Appendix 9 Response From A Local Resident

Re: The demolition of 40 Victoria Roads, the erection of 5 detached dwellings on land at the rear of 40 Victoria Road and the formation of a new access onto Victoria Road.

Figure 5: Proposed plot layout and driveways

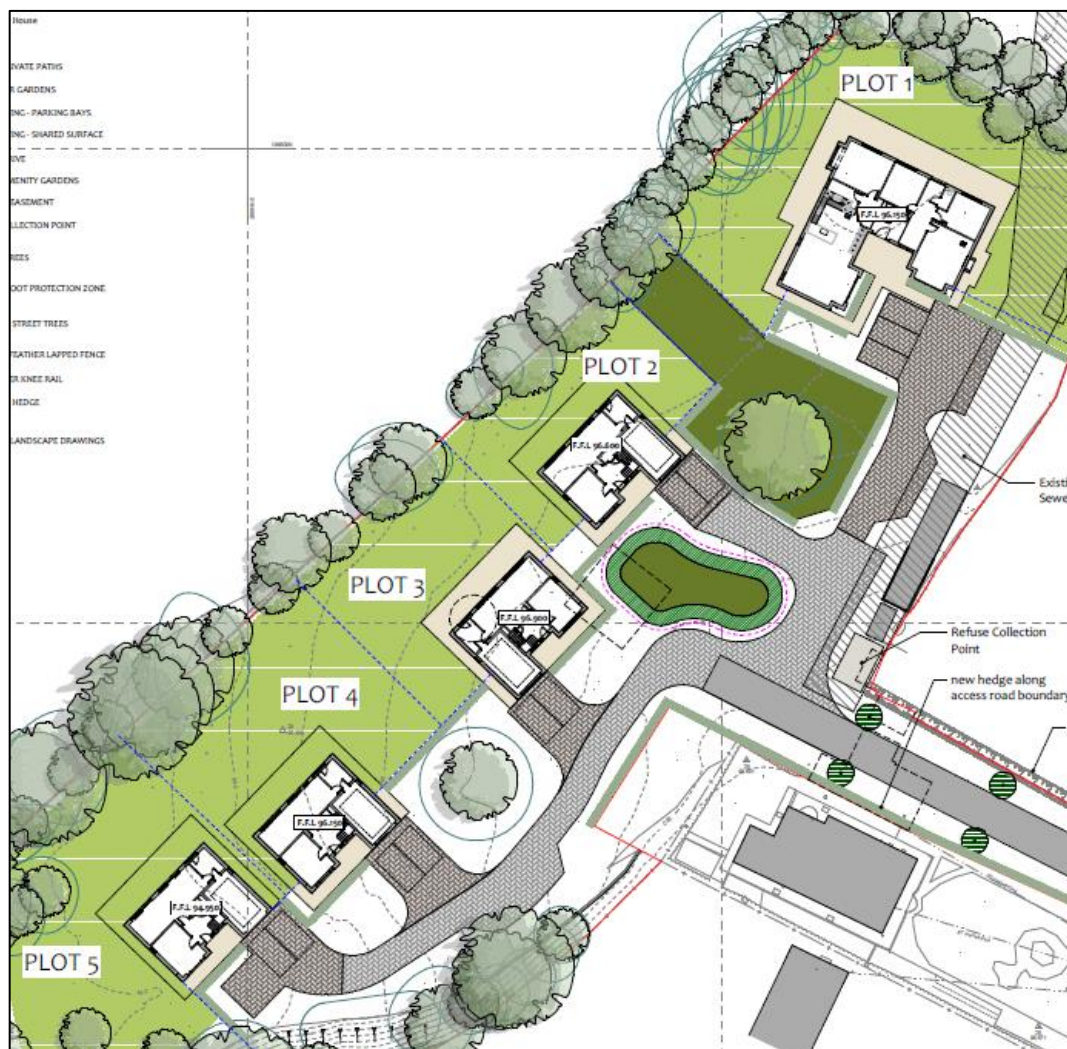
We have concerns regarding the apparent lack of representation for properties 25, 26 and 27 Victoria road on any of the proposal documentation and plans.

Our concerns are particularly around the placement of 'House type 3' and its rear balconies which would give a direct line of site into the upstairs rooms of 25 and 26 Victoria Road through the existing, thin tree line.

In the plans as they currently are, it seems the area that these properties occupy is represented by a stone wall that no longer exists.
